Reviewed for Code Compliance
Inspections Division
Approved with Conditions
Date: 10/10/14

July 22, 2014
Revised: September 29, 2014

RE: 102 Portland Street

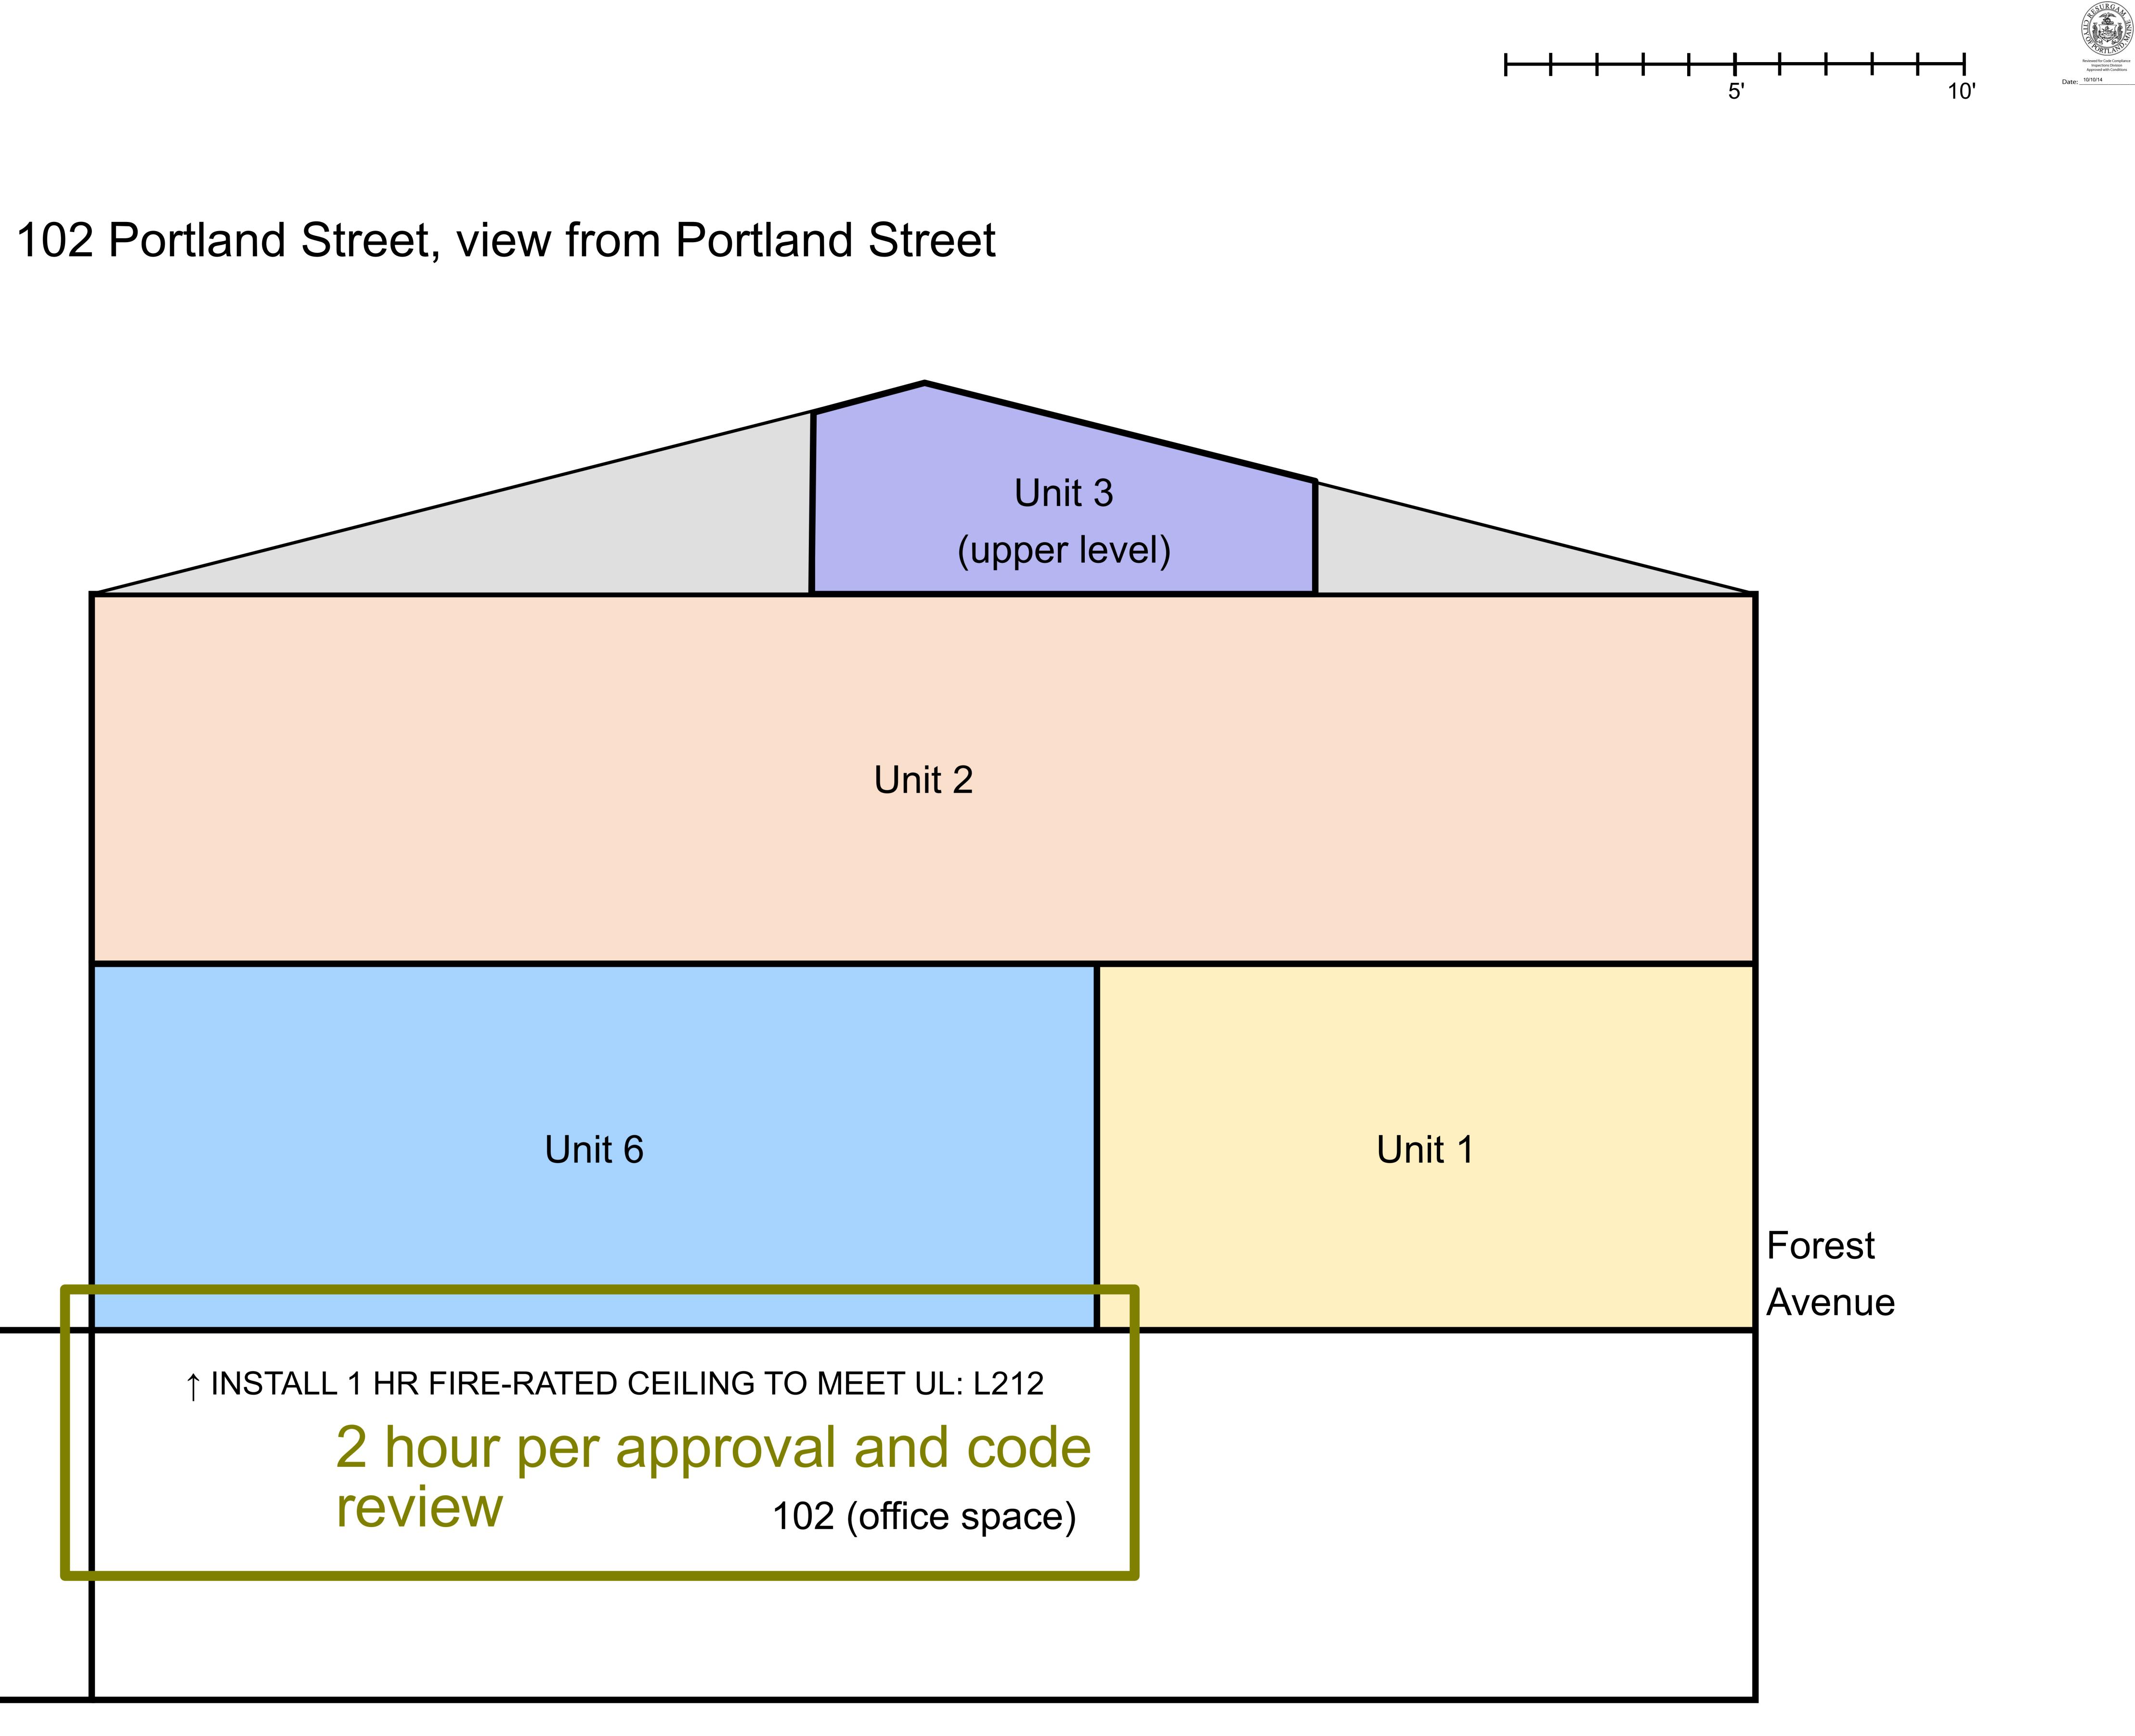
1. The 1st floor Mercantile or Business use must be separated from the residential uses by a floor/ ceiling assembly with a one hour fire rating. The space contains a suspended acoustical tile ceiling with no fire rating currently. We propose a **2 Hour** fire rated floor/ ceiling assembly by a suspended GWB ceiling meeting UL L212.
